Subject: SSD: Notice of Exhibition Ingleburn Battery Recycling Facility SSD 7195 (Campbelltown LGA)
- 10 Lancaster St, Ingleburn - 2889/2016DA-SSD (additional comments)

Council's further comments to the proposal are below:

**Acting Coordinator Development Assessment Unit
Campbelltown City Council**

dwg title :
**EXISTING WAREHOUSE
ELEVATIONS,SECTION & FFPLAN**

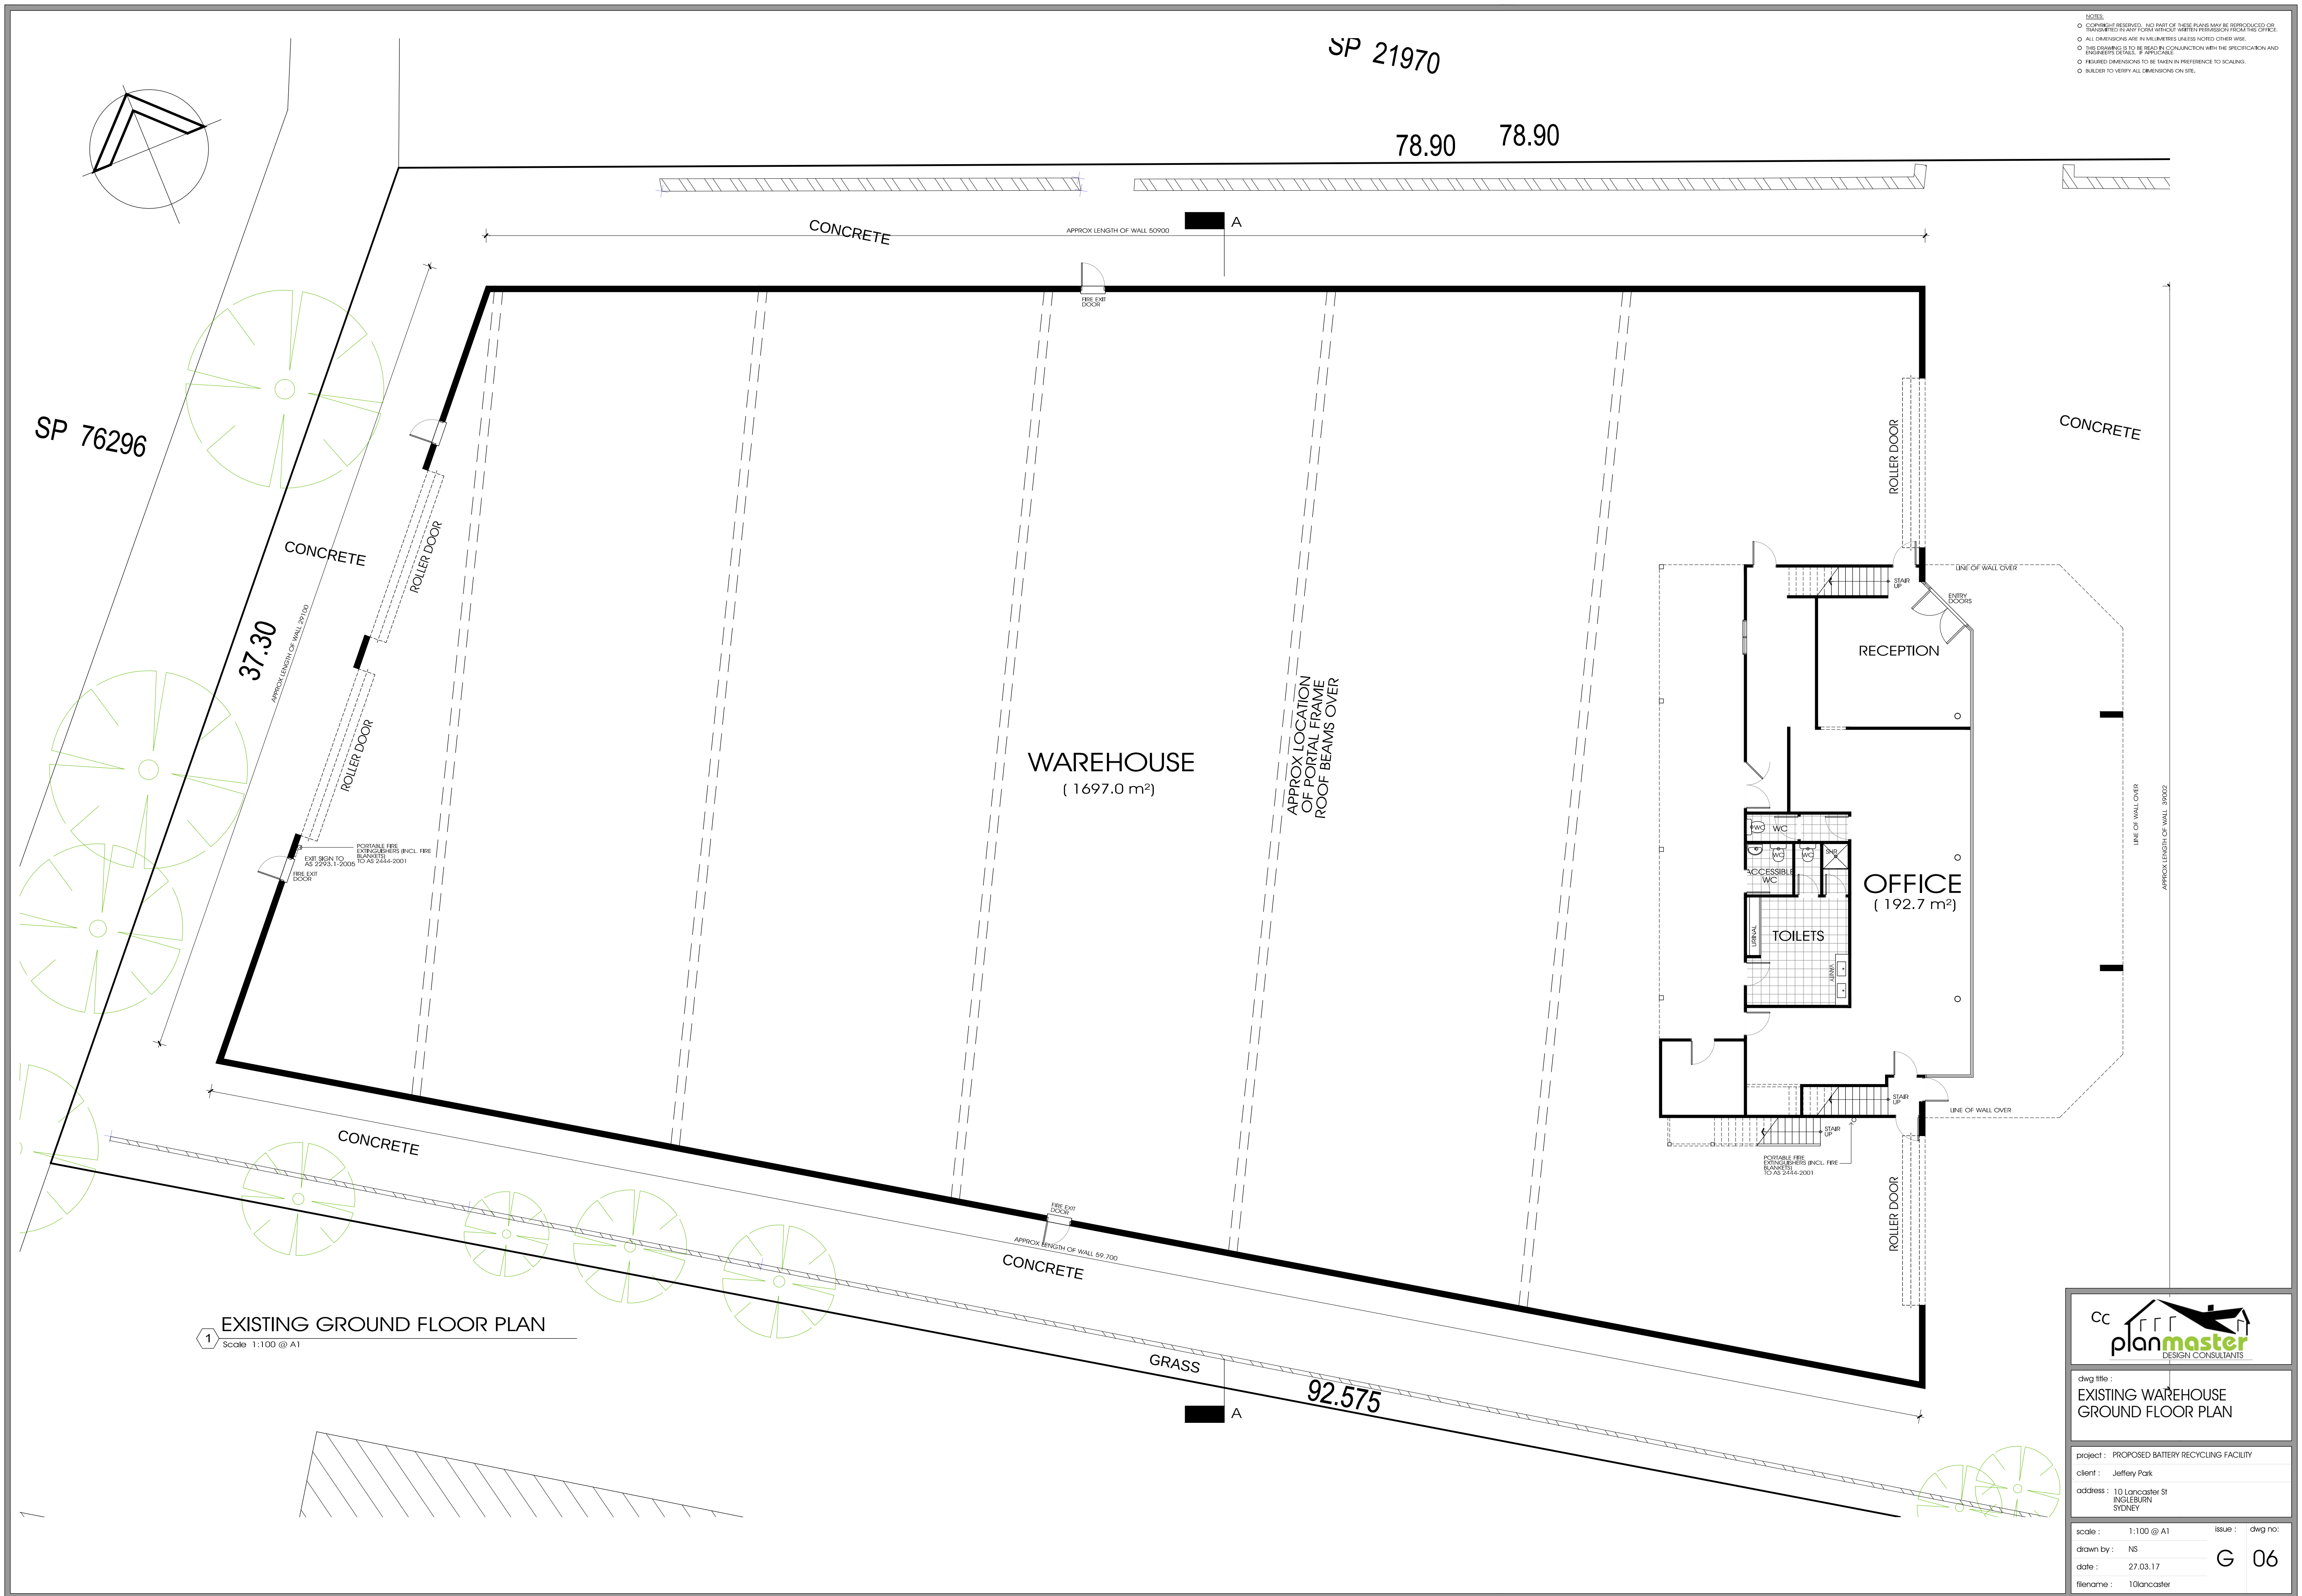
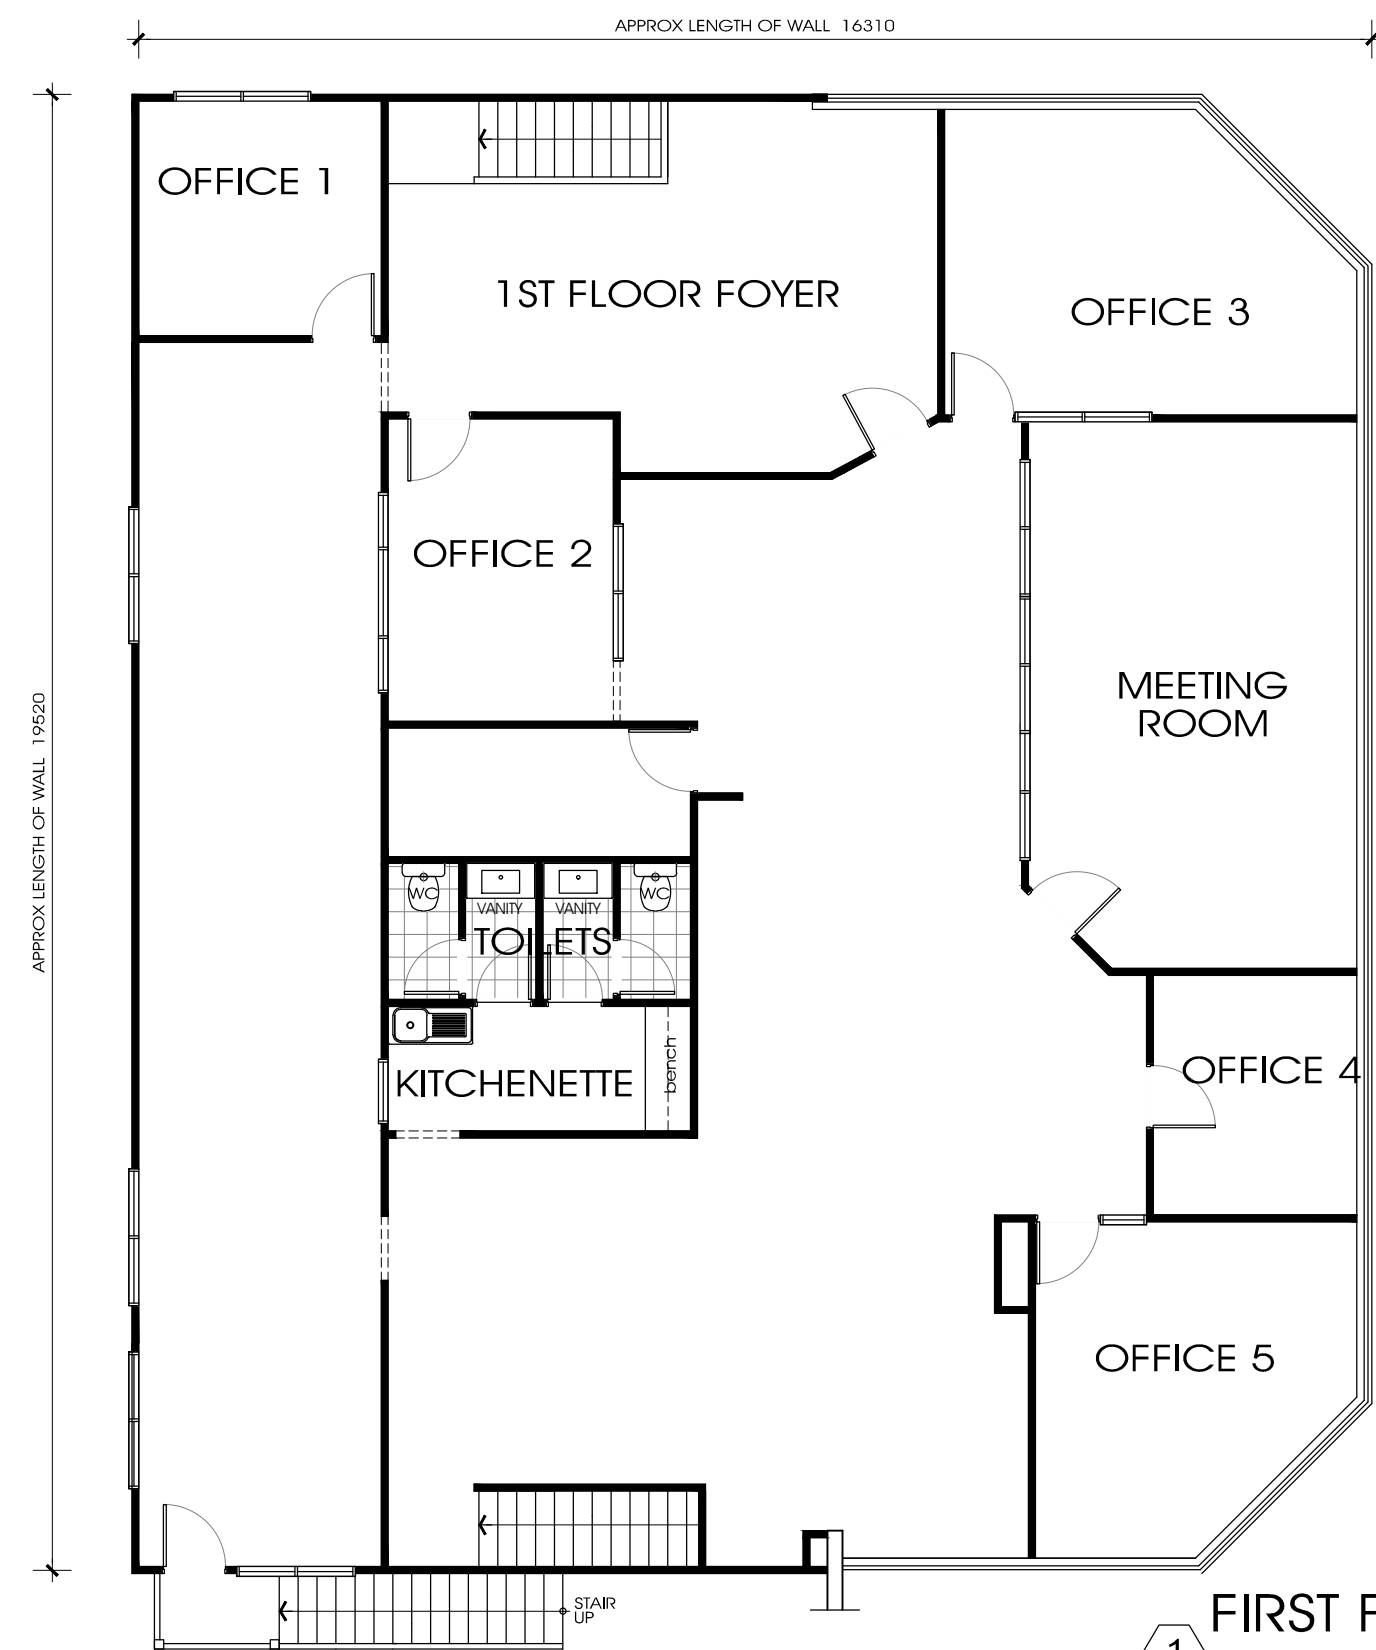
The amended Architectural Plan indicates that there is a small kitchenette will be located on the first floor however its dimensions are not shown as the plan has no measurements. There is no dedicated lunchroom on the plan – this needs to have a

separated space with sufficient room for tables and seating and a door. The toilet access is unhygienic being located through and directly adjoining the two toilets.

- Prior to Construction Certificate an amended Architectural Plan with measurements of rooms is to be provided showing a dedicated lunchroom with sufficient space for tables and seating and a door to accommodate all the staff employed on the site. The toilets are to be separated and not to be accessible directly from the kitchenette; the plan is to be submitted for Council's or the PCA's prior written approval.
